10/23 Planning Board Meeting - Maine Med Proposal

I think the Maine Med latest proposal is definitely more respectful and considerate to the residential neighborhood around Maine Med. Thanks to Maine Med working with the neighborhood organization representatives to address the residents concerns.

TITLE  
**LANDSCAPE PLAN,  
CONGRESS AND  
GILMAN STREET**

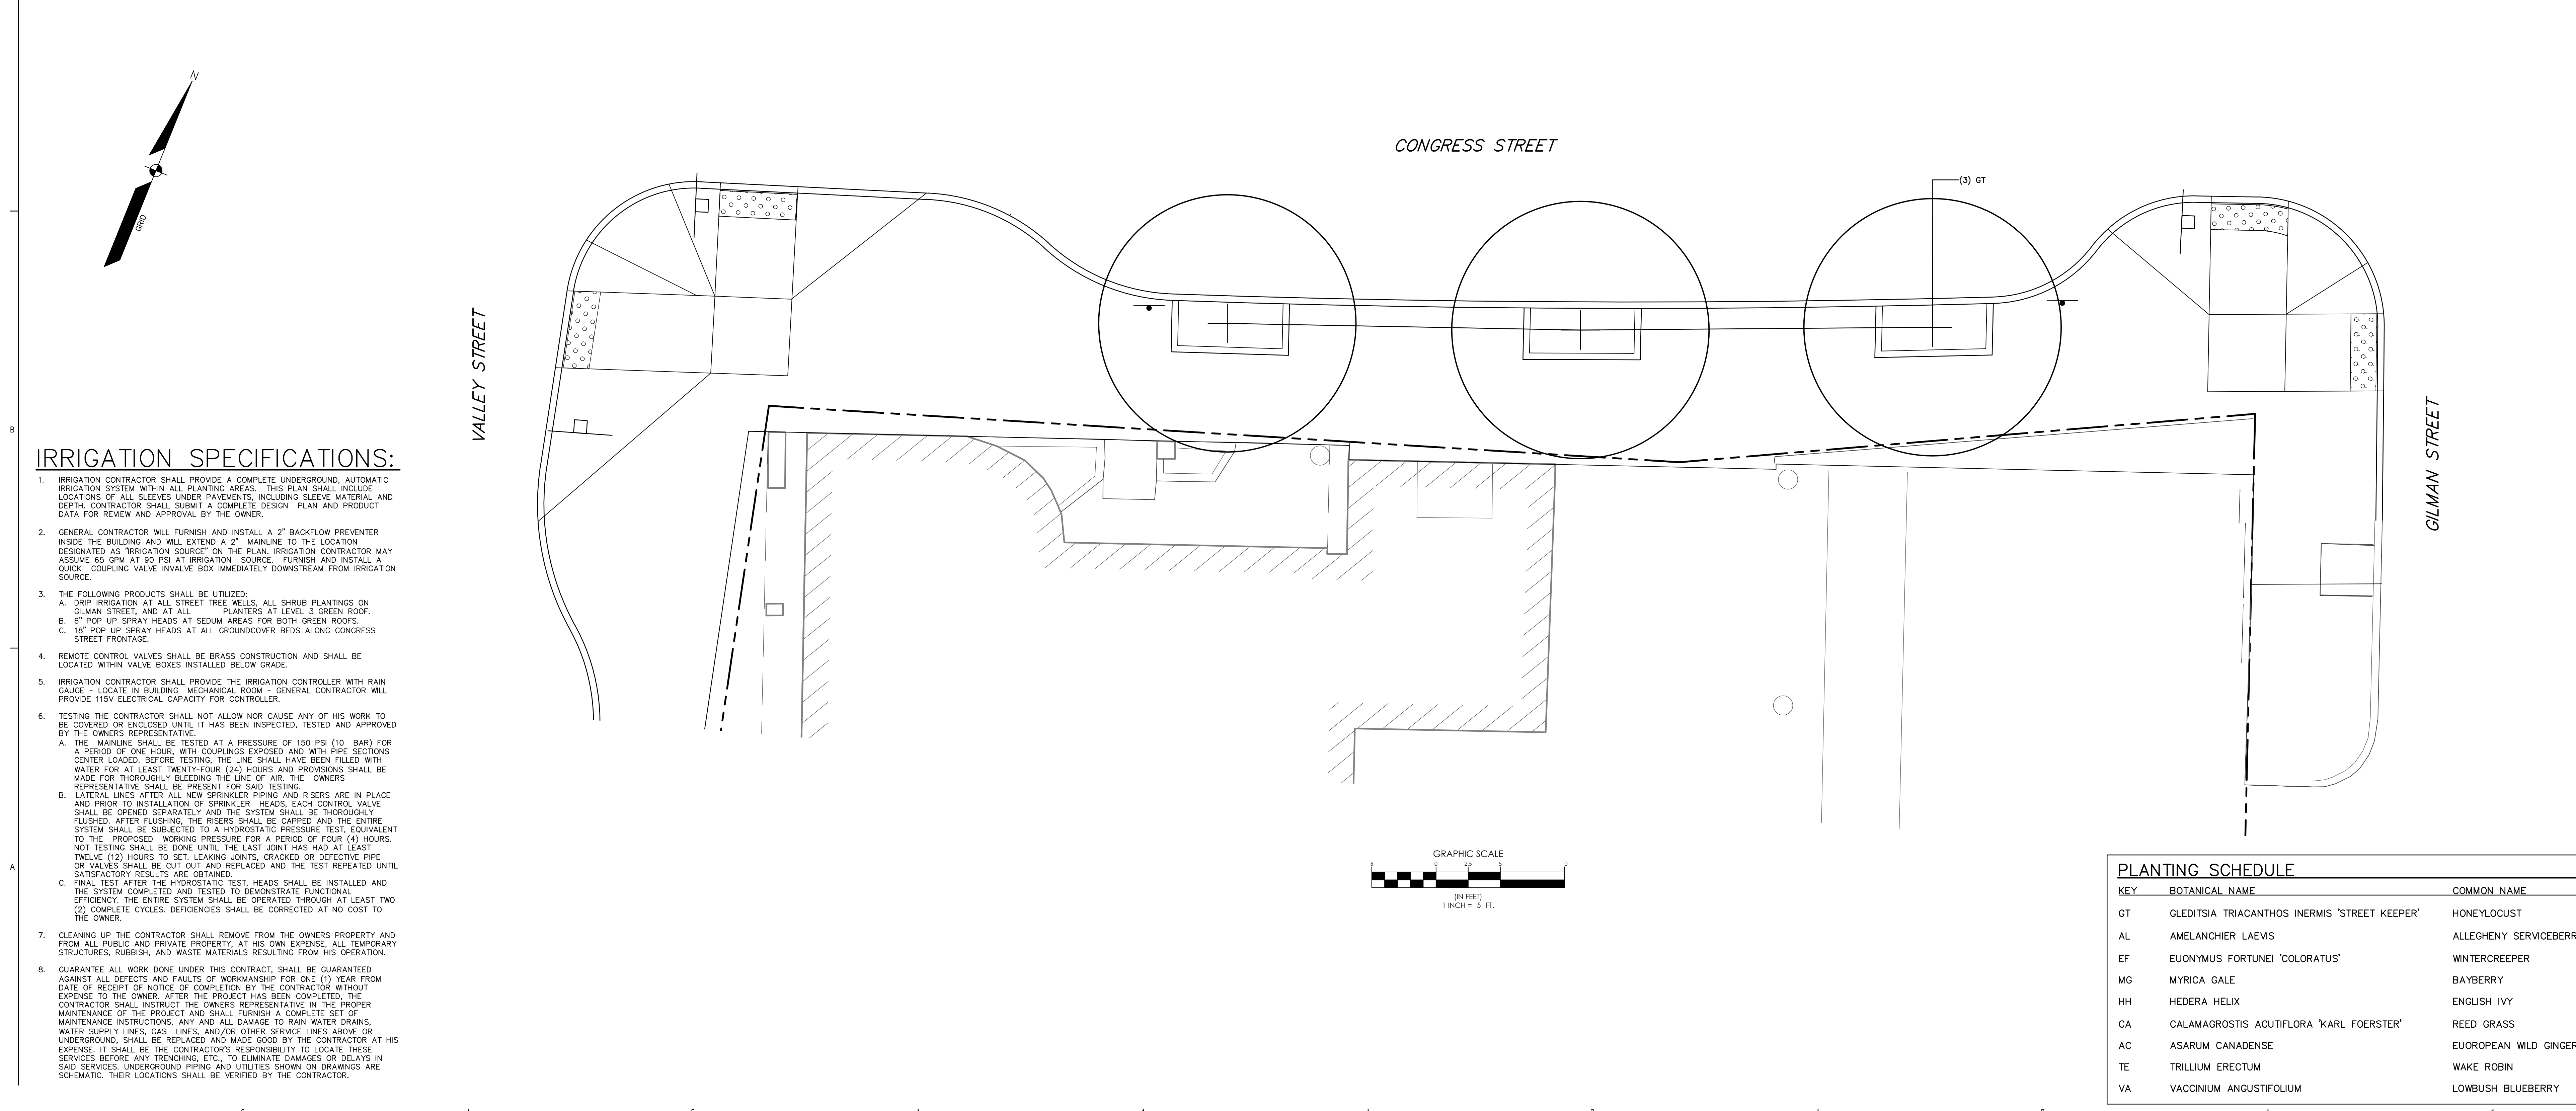
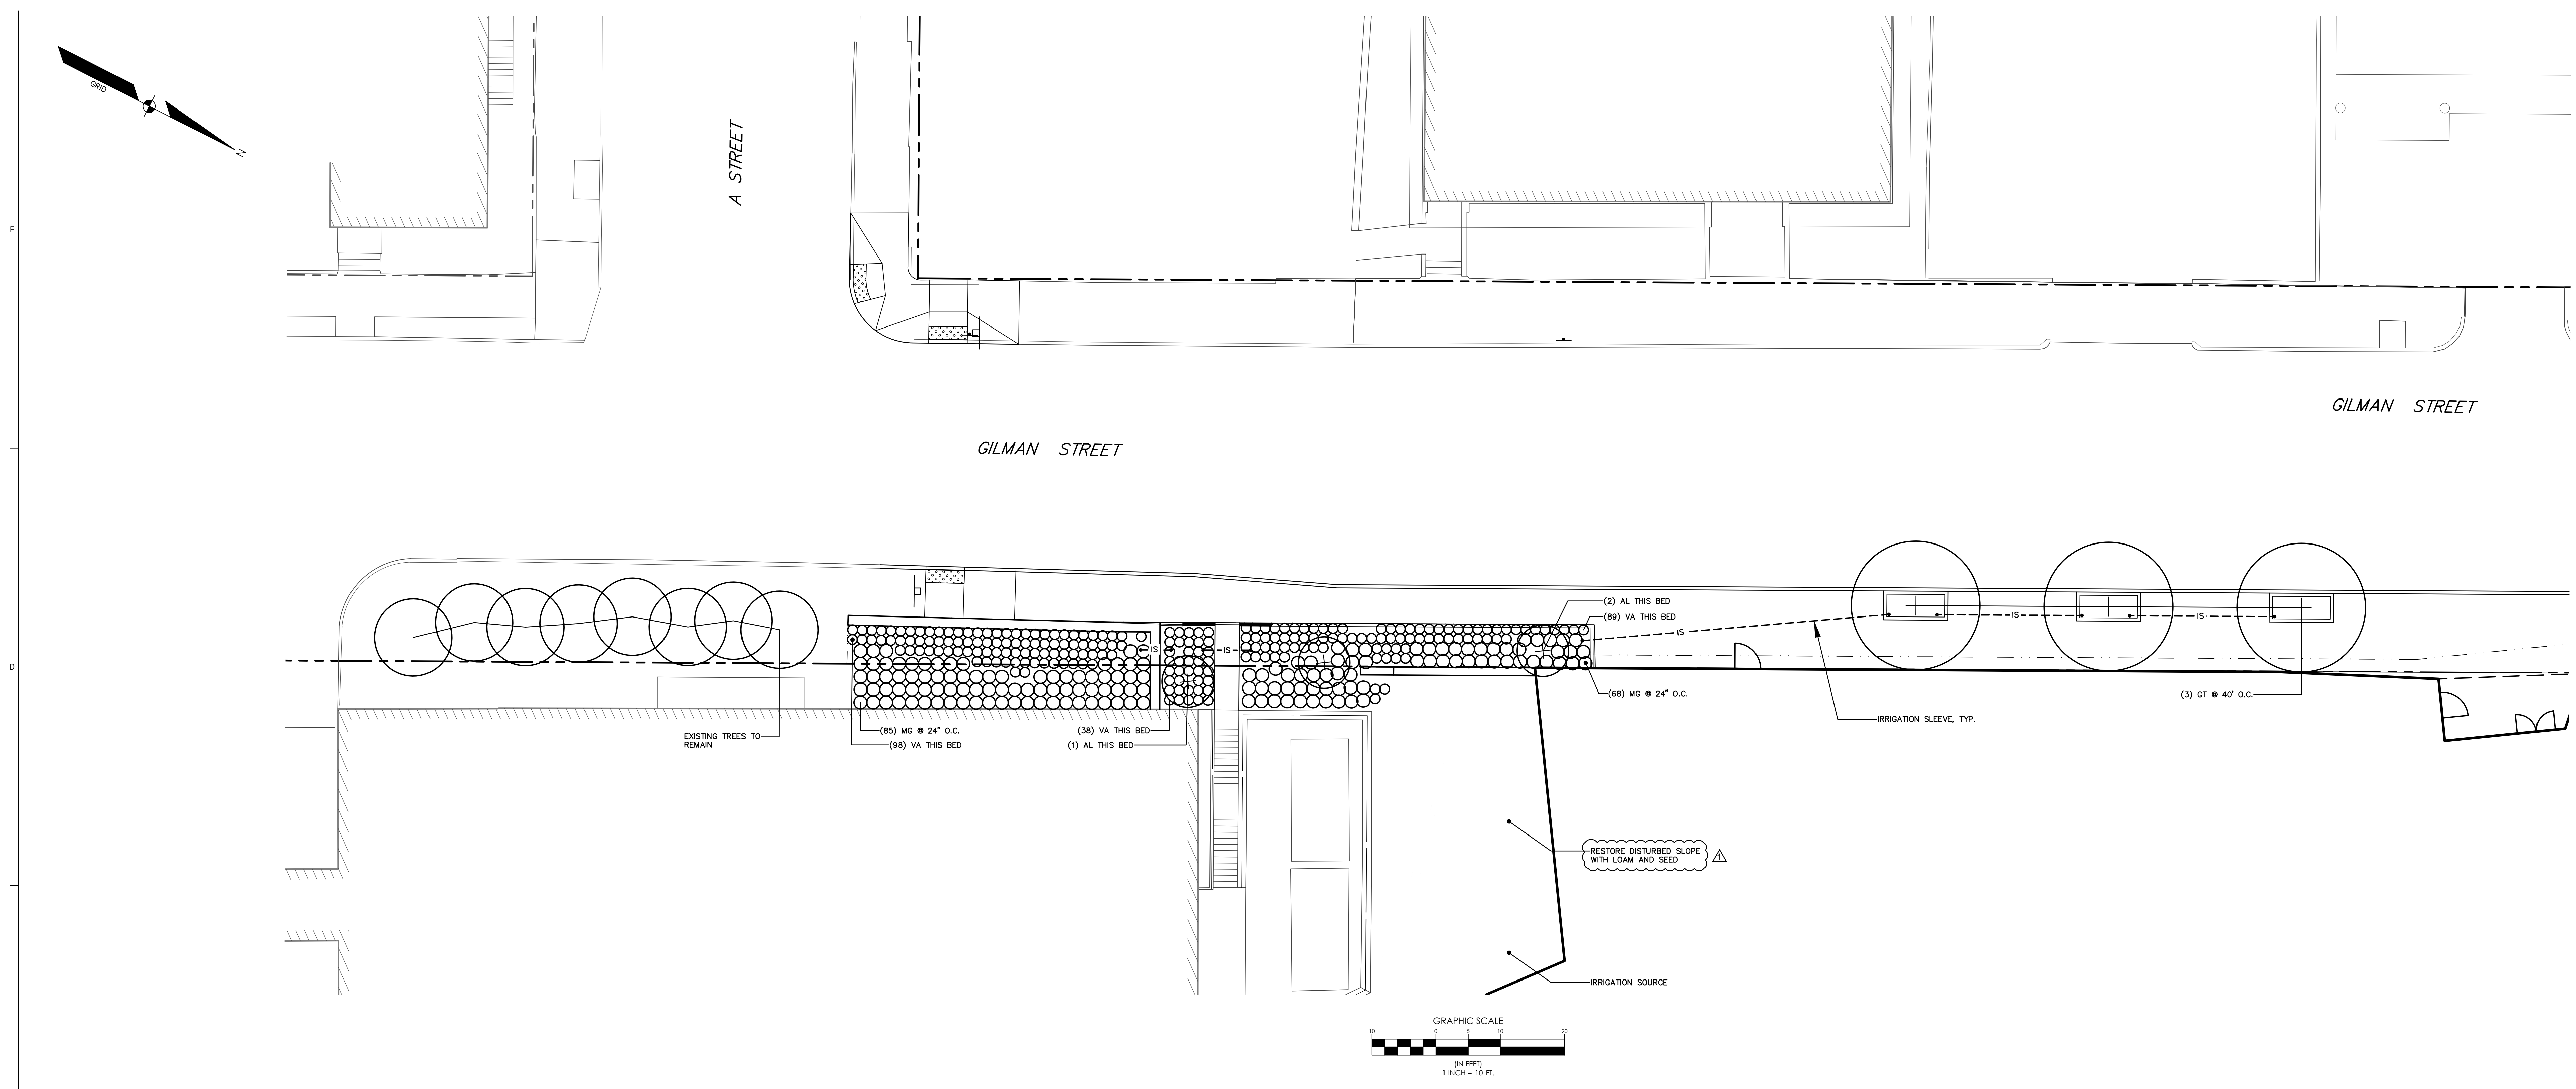
3) I was surprised to hear the 12 mature oak trees that are on the Maine Med property close to the parking garage will be replaced with a 8 medium sized street trees called the Honey Locust. Also, I was surprised to see this tree on Portland's recommended tree list since it is not even native to Maine and climate zone. In fact, from the Portland's Recommended Street Tree list, only 1 of Portland's recommended medium street trees are actually a native to Maine as shown below. However, the recommended large street trees are mostly native to Maine... except for the Catalpa and that junk tree, ginkgo biloba from China.
